Development Facilitation Team (DFT) – Review Comments

DRB Project No: PR-2021-004968 Date: 1/08/2025 Agenda Item: #3 Zone Atlas Page: C-10

Application For: SD-2024-00167 – FINAL PLAT (DHO)

Project Name: La Cuentista Phase 4

**Plat for
La Cuentista
Subdivision, Phase IV
Being Comprised of
Tract B-1-A-1, La Cuentista
Subdivision, Phase I
City of Albuquerque
Bernalillo County, New Mexico
November 2024**

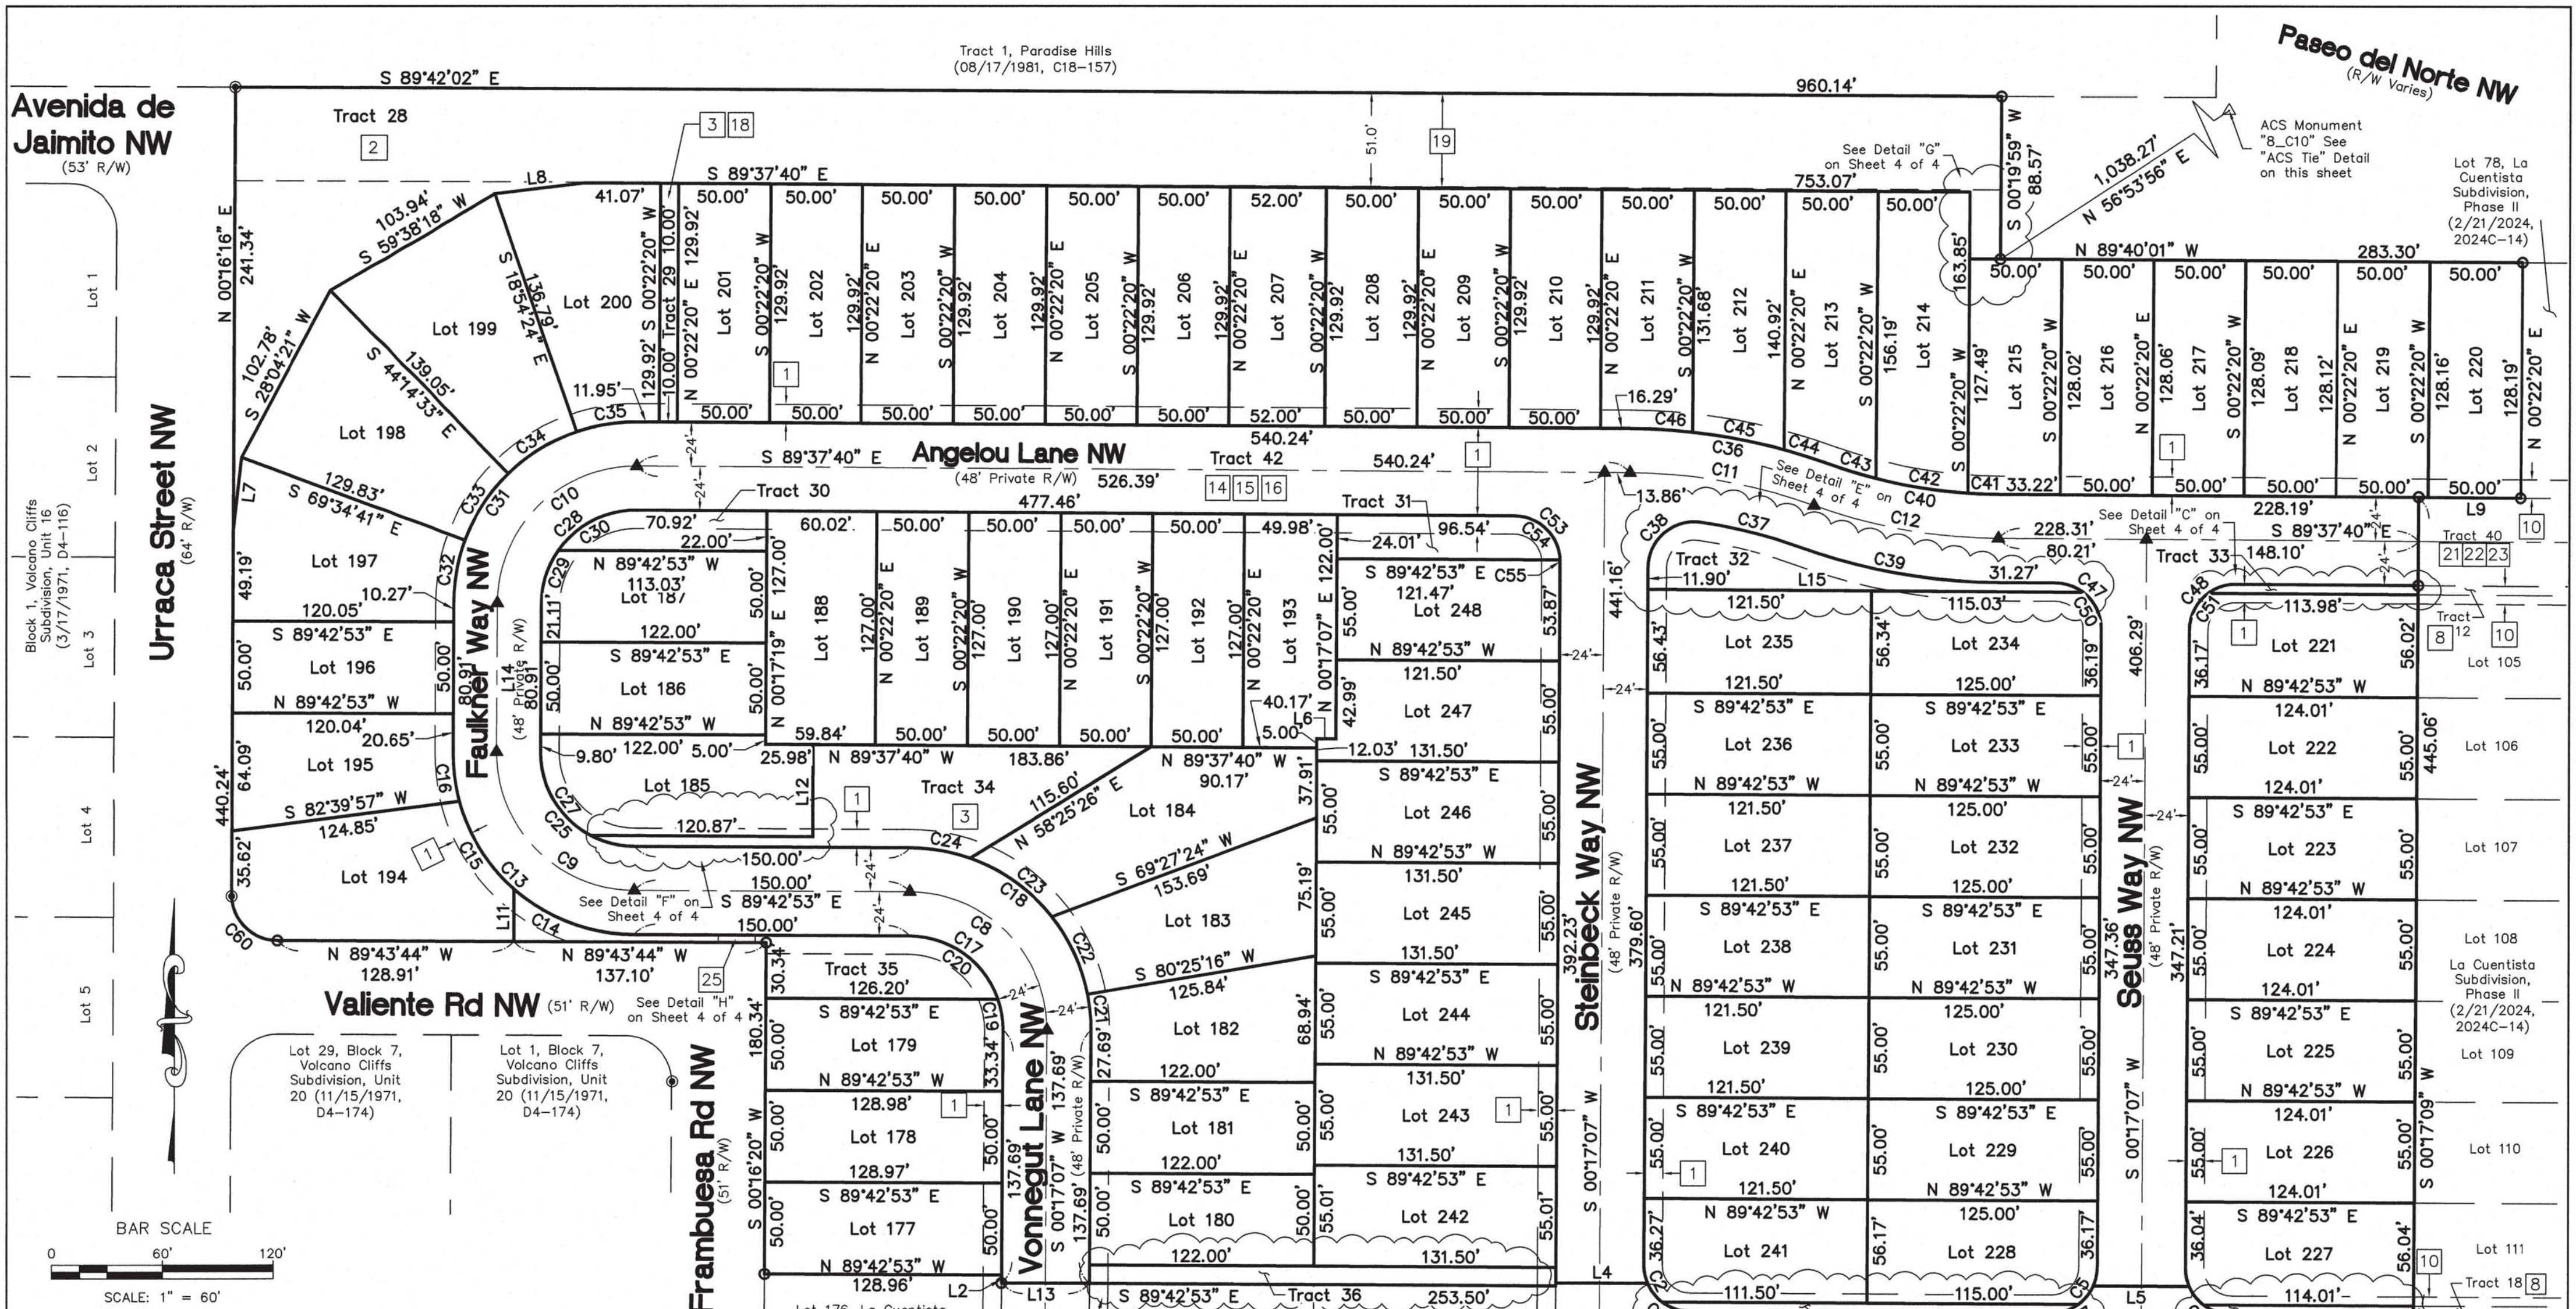
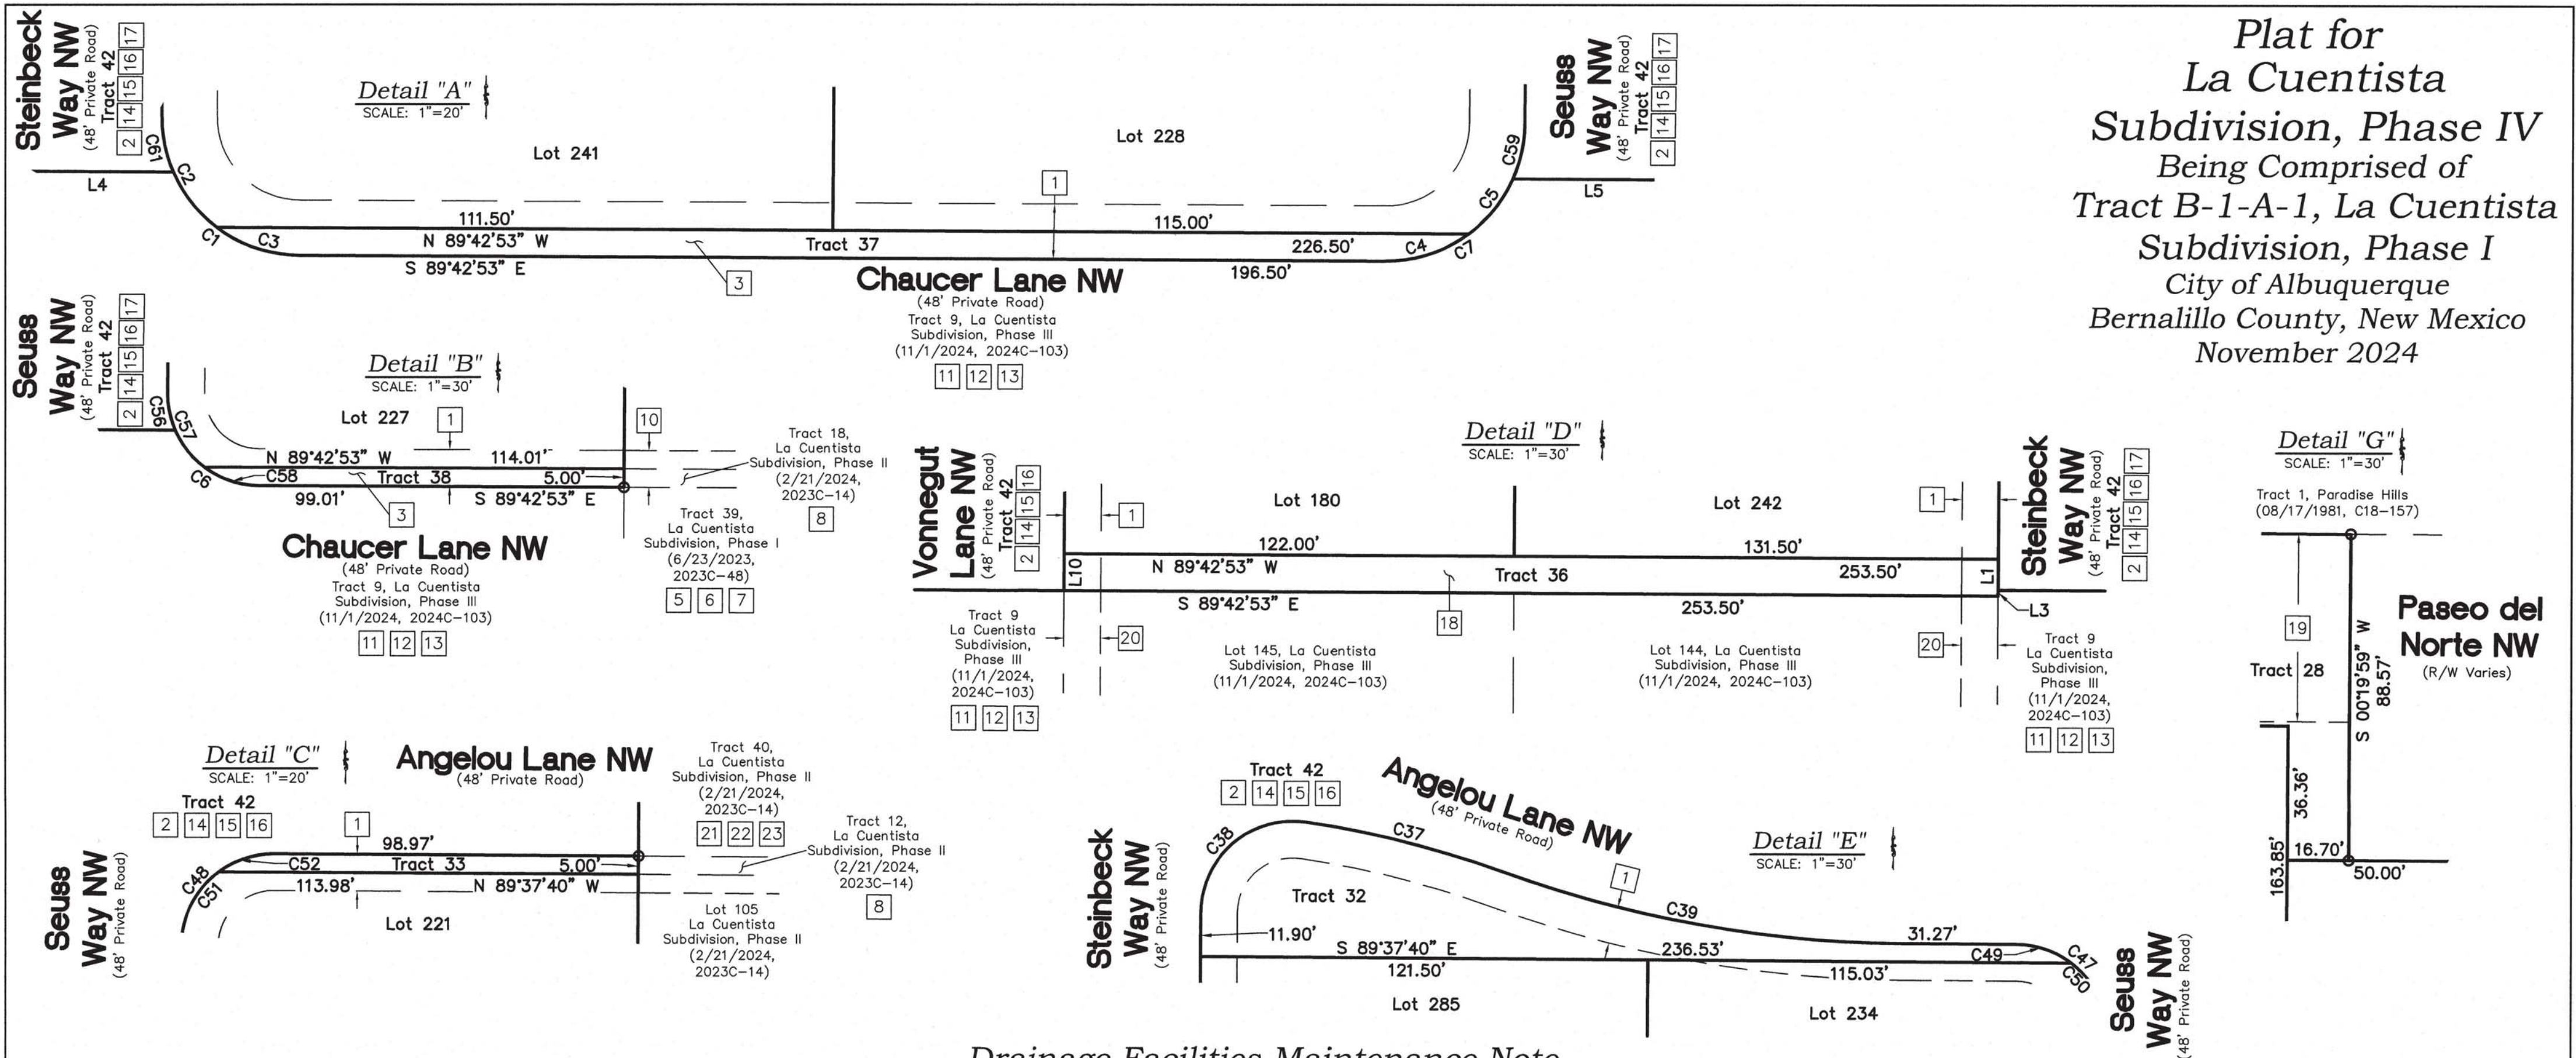
- There is an inconsistency with the wall exhibit shown on pg.12 of the submittal. The wall exhibit shows the eastern boundary as ending at lots 234-228. The phase 4 plan shows the eastern boundary ending at lots 220-227. Please confirm the eastern boundary and adjust the wall exhibit to reflect that correctly.
